**Application by East Anglia ONE North Ltd for East Anglia ONE North Offshore Wind Farm  
Application by East Anglia TWO Ltd for East Anglia TWO Offshore Wind Farm**

**The Examining Authorities' written questions and requests for information (ExQs3)**

**Issued on 20 May 2021**

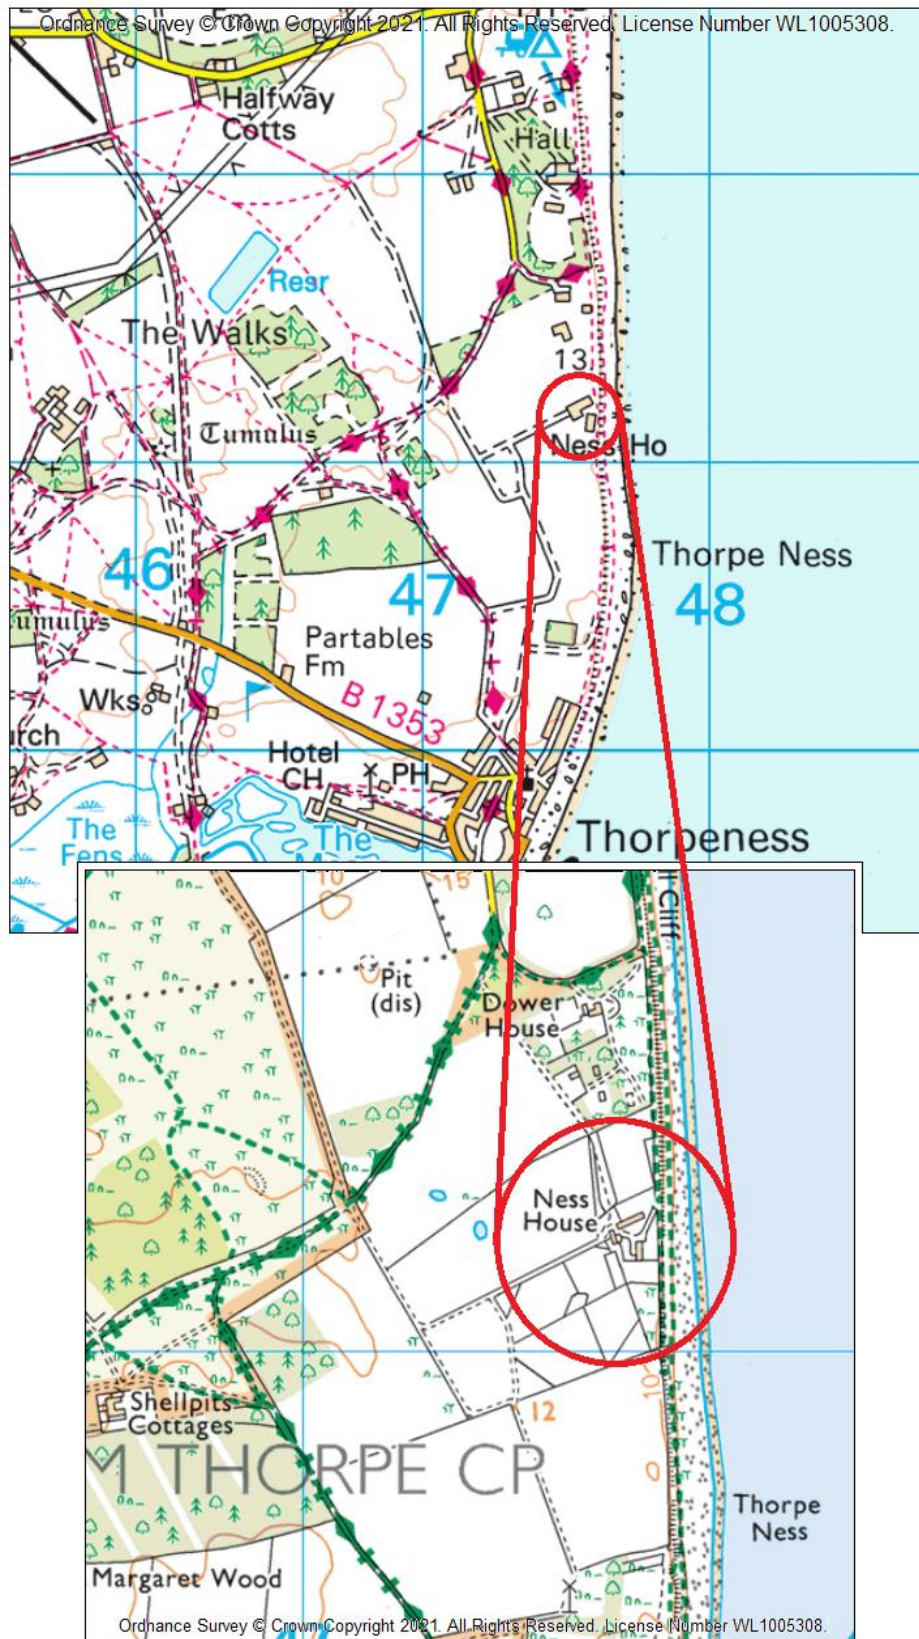
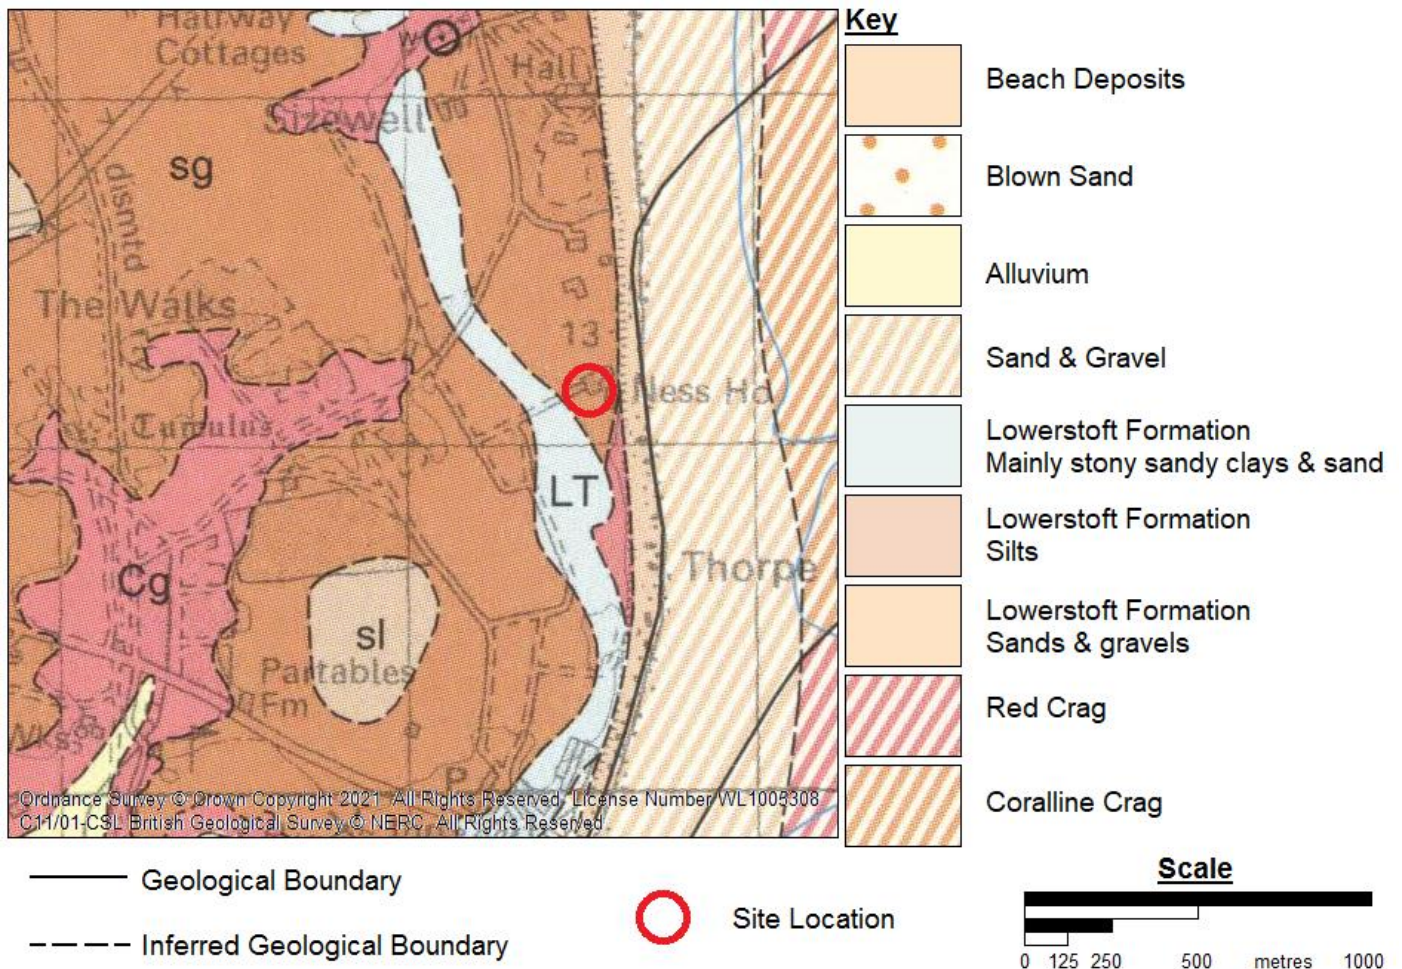
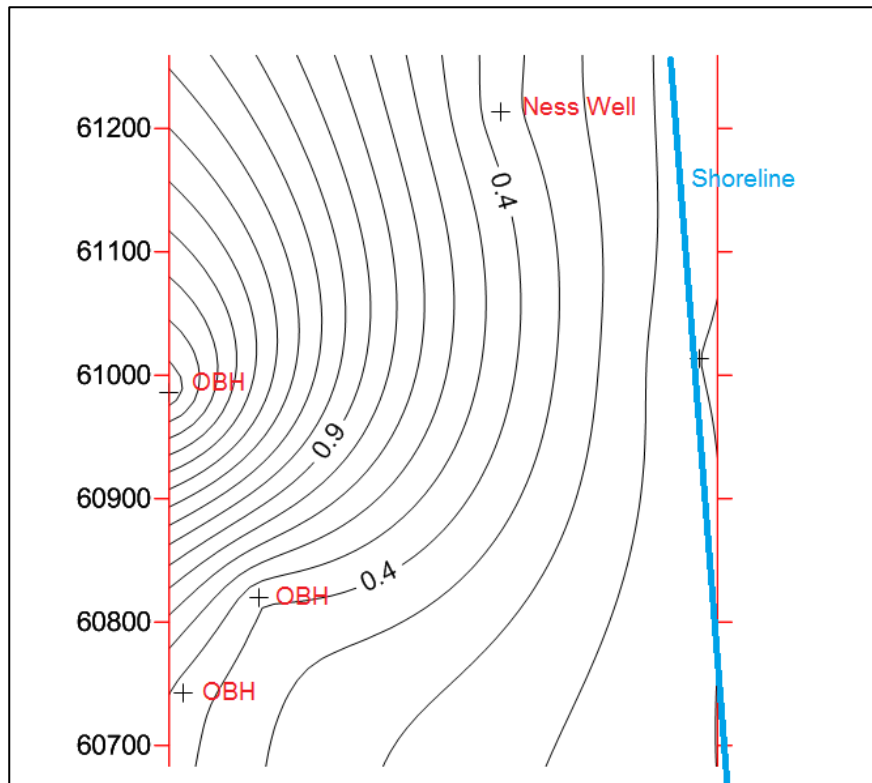
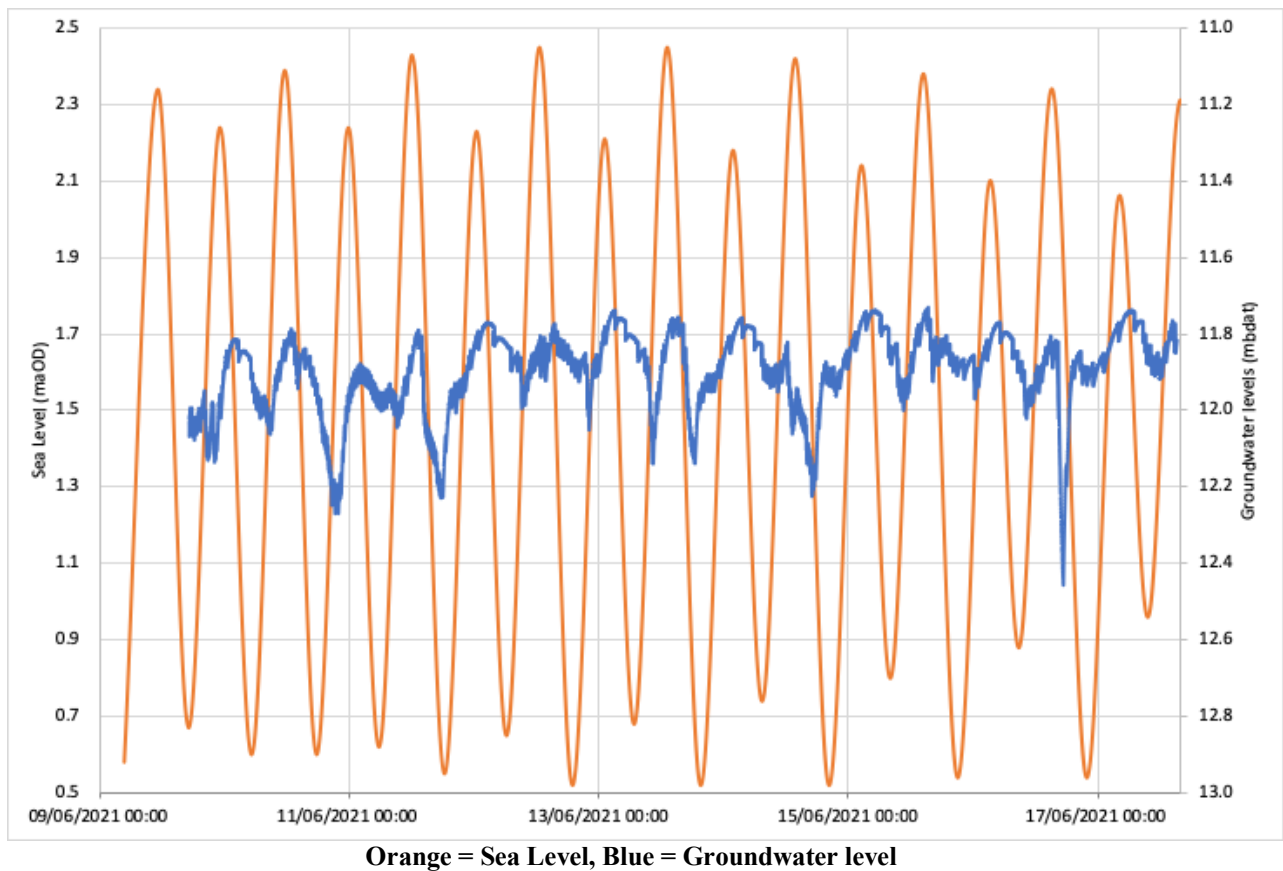
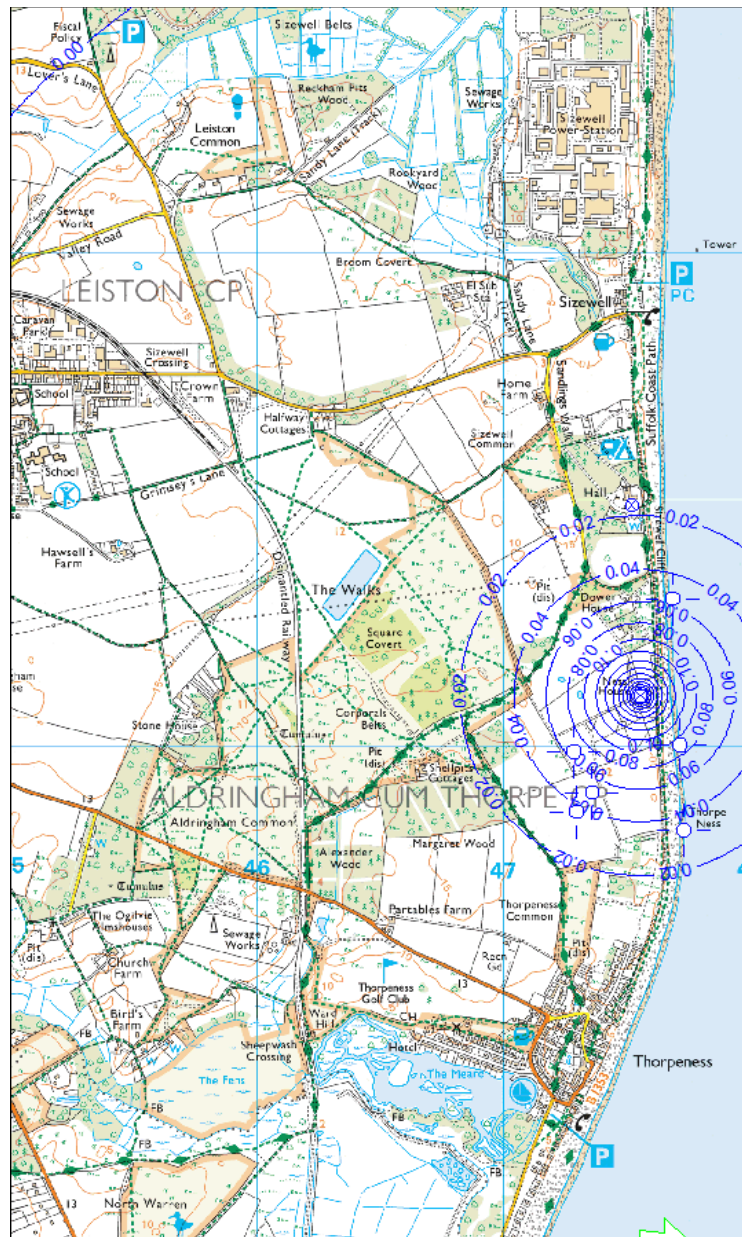
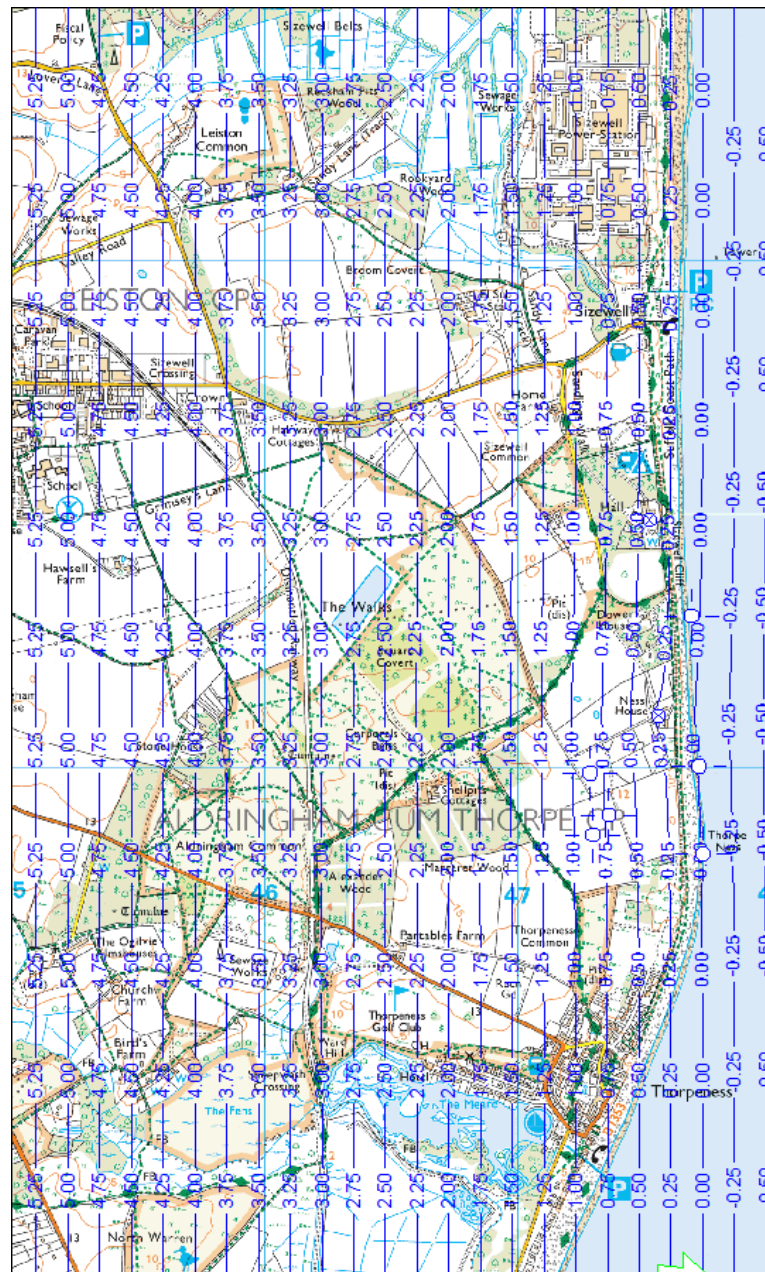
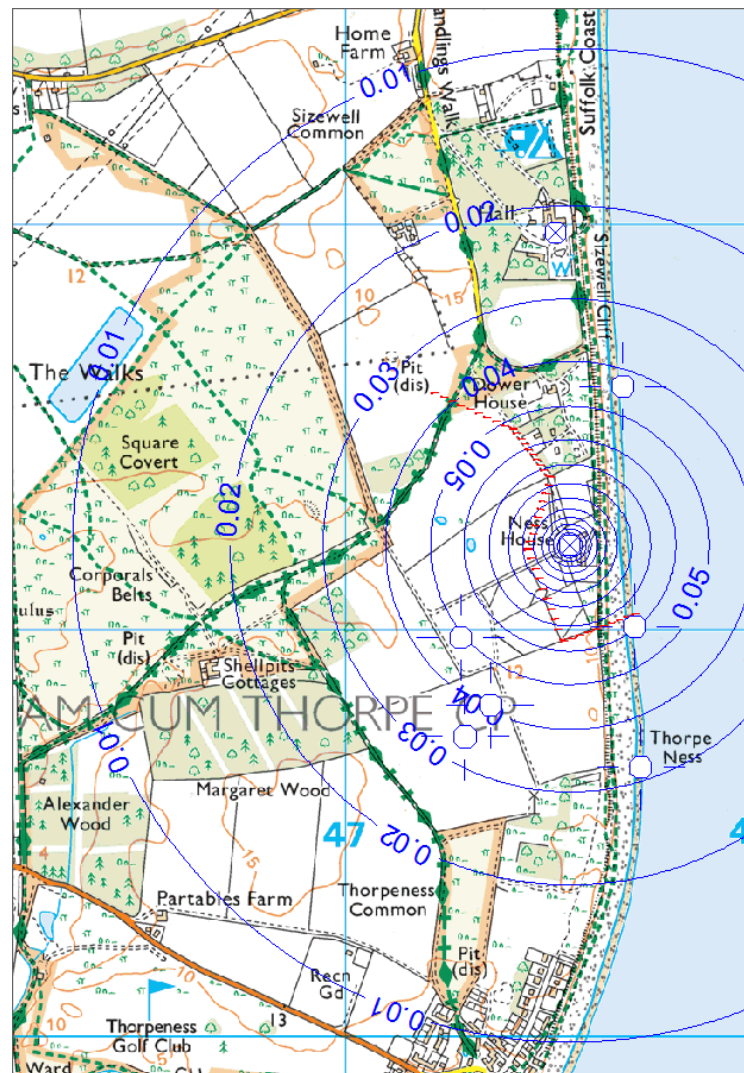
3.7.2.	The Applicants	<b>1</b>	<b>2</b> <b>Water supply at Ness House well</b> Please provide more detailed information on the proposed water quality and levels monitoring regime at Ness House well and the temporary potable water supply that is proposed to be tied into the well for the duration of HDD activities.

Coralline Crag

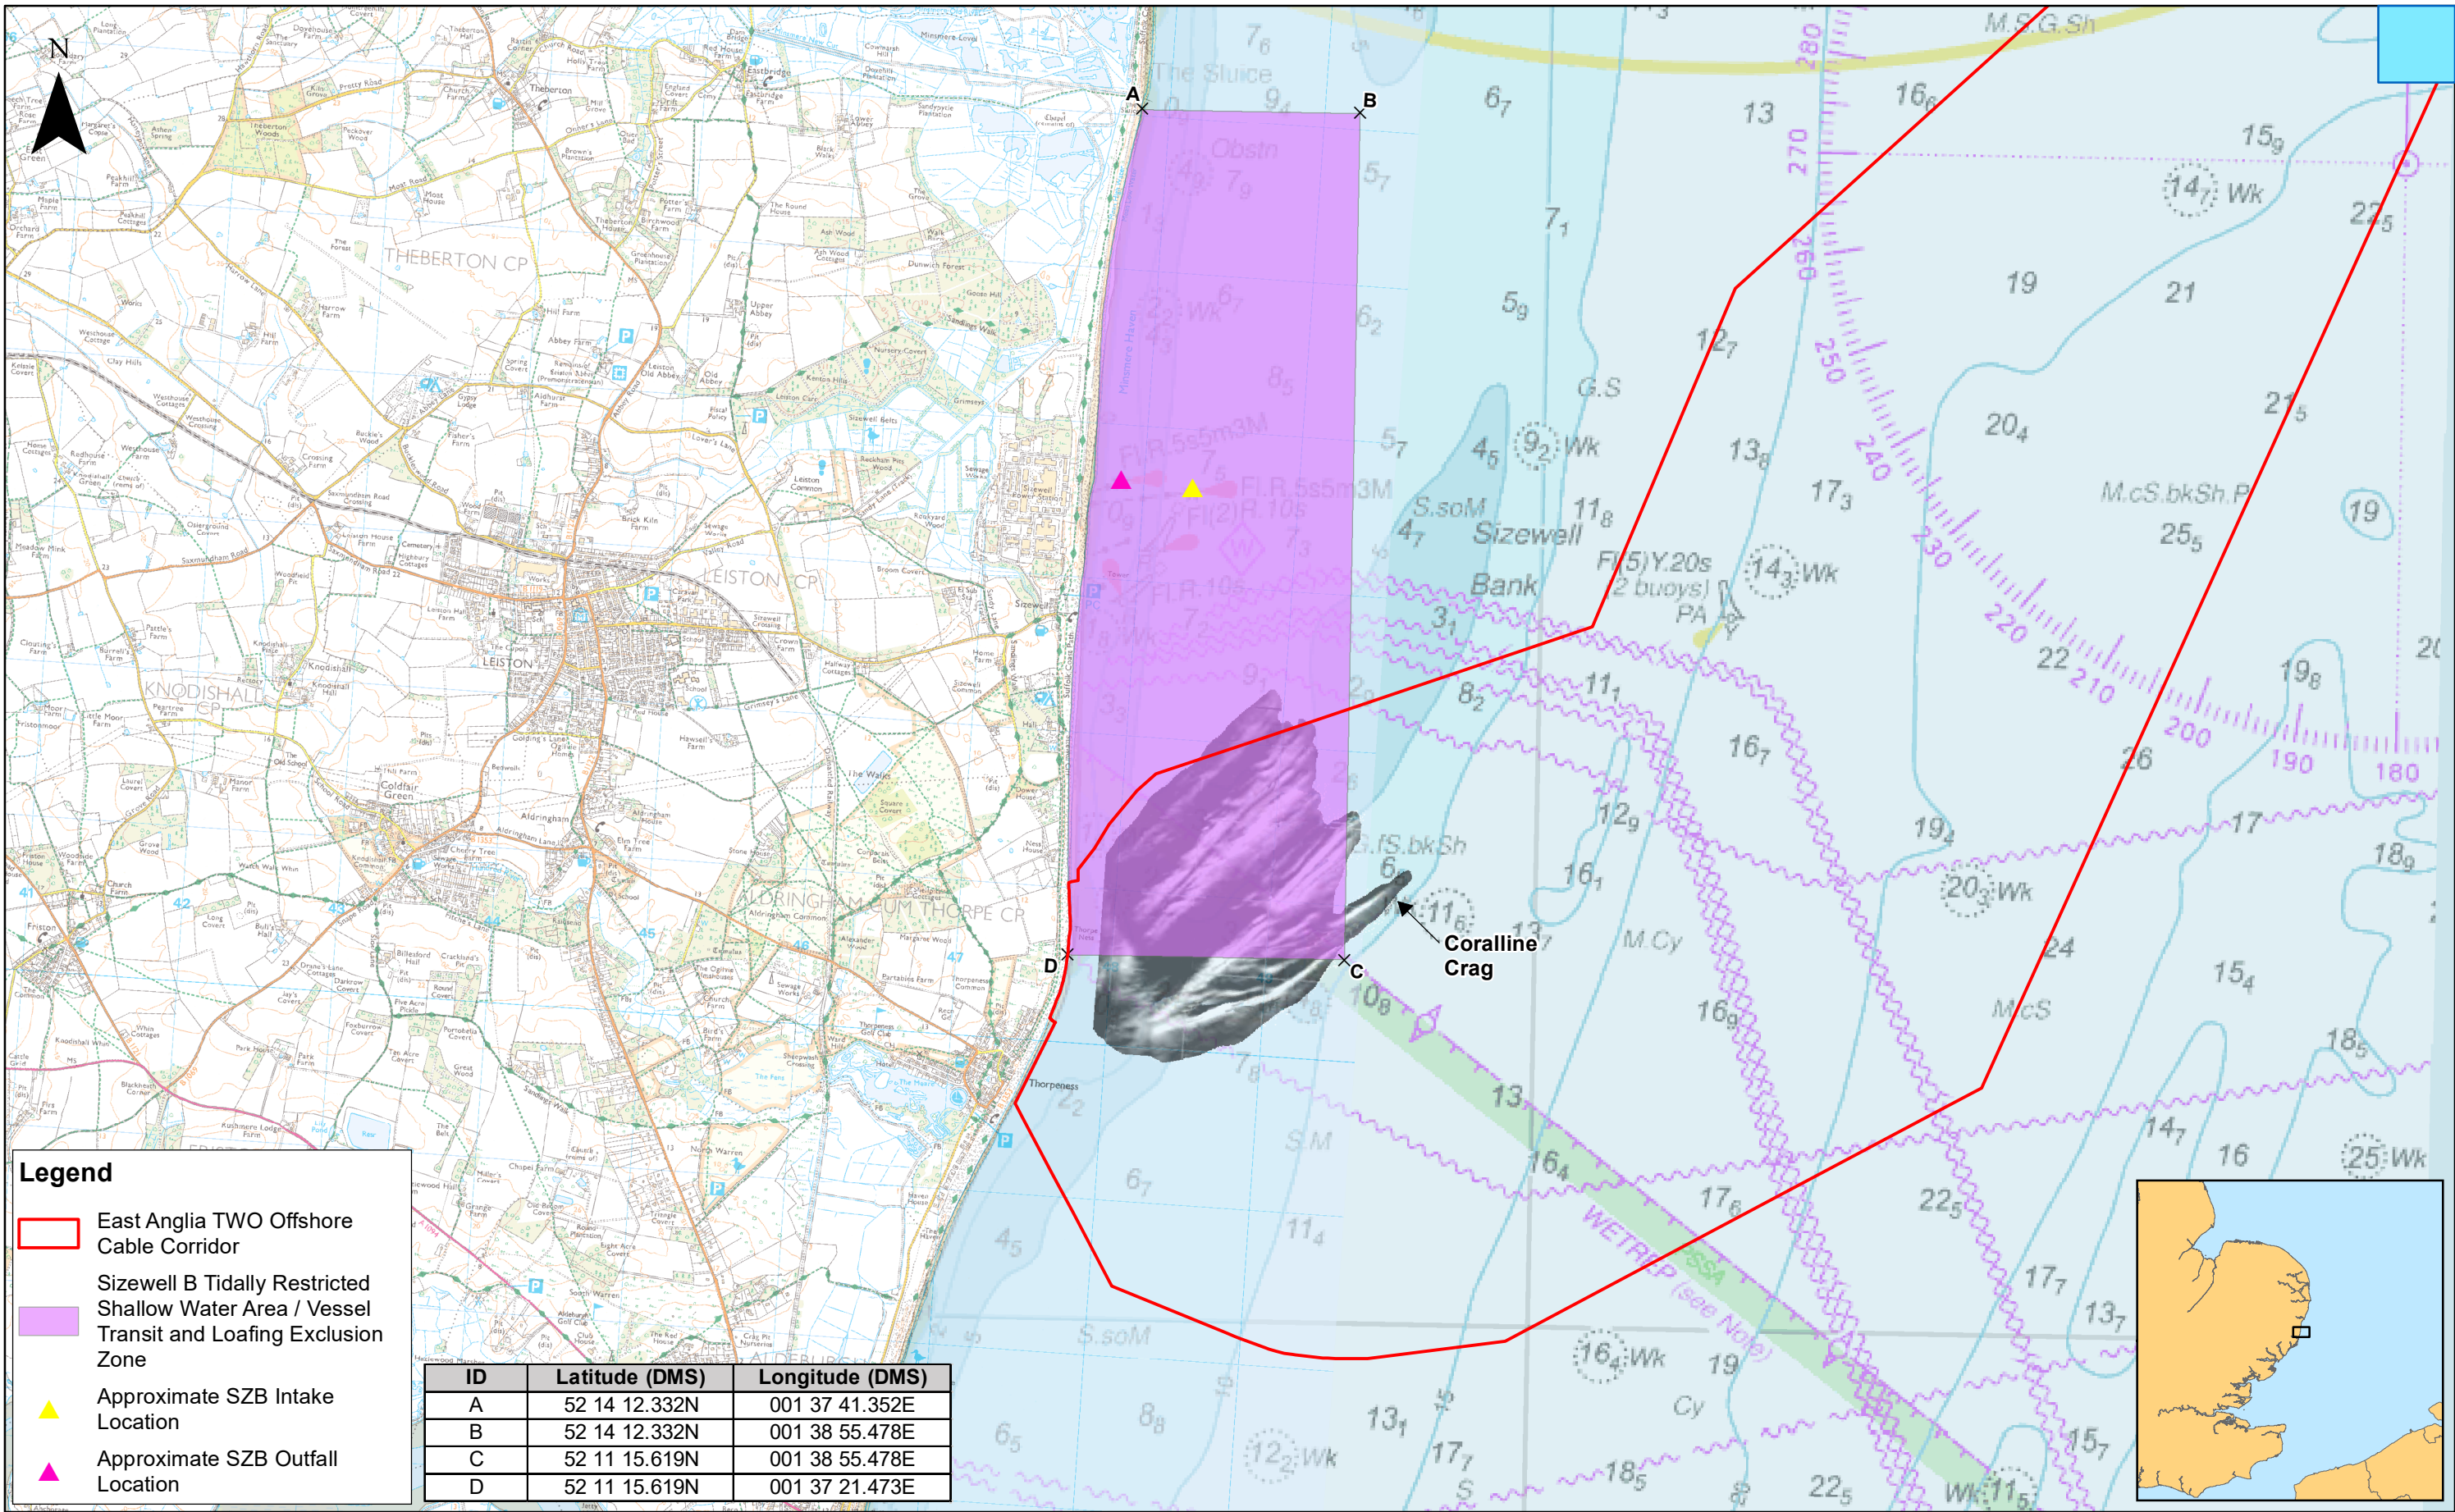
3.11.1.	EDF Energy Nuclear Generation Ltd, ESC, MMO	<b>1</b>	<p><b>2</b> <b>Avoidance of the Coralline Crag</b></p> <p>Paragraph 15 of the Landfall Hydrogeological Risk Assessment [REP6-021] states that the HDD is expected to be within the Coralline Crag beneath the cliffs, and the strength of the Coralline Crag is expected to prevent any drilling fluid breakout at this point. In [REP8-052] the Applicants state that complete avoidance of the Coralline Crag has never been proposed. The Applicants go on to state any reference to avoiding direct physical disruption to the outcrop of Coralline Crag refers to the parts of the Crag that are visible at the surface; the HDD bores as proposed pass through the Coralline Crag, but beneath its visible surface before 'punching out'.</p> <p>a) Please could you confirm that in referring to the avoidance of direct physical disruption to the outcrop of Coralline Crag it was also your understanding that this meant only those parts visible at the surface and that the HDD bores would in fact pass through the Coralline Crag?</p> <p>b) If this was not your understanding does this cause any concern and what would be the implications?</p>
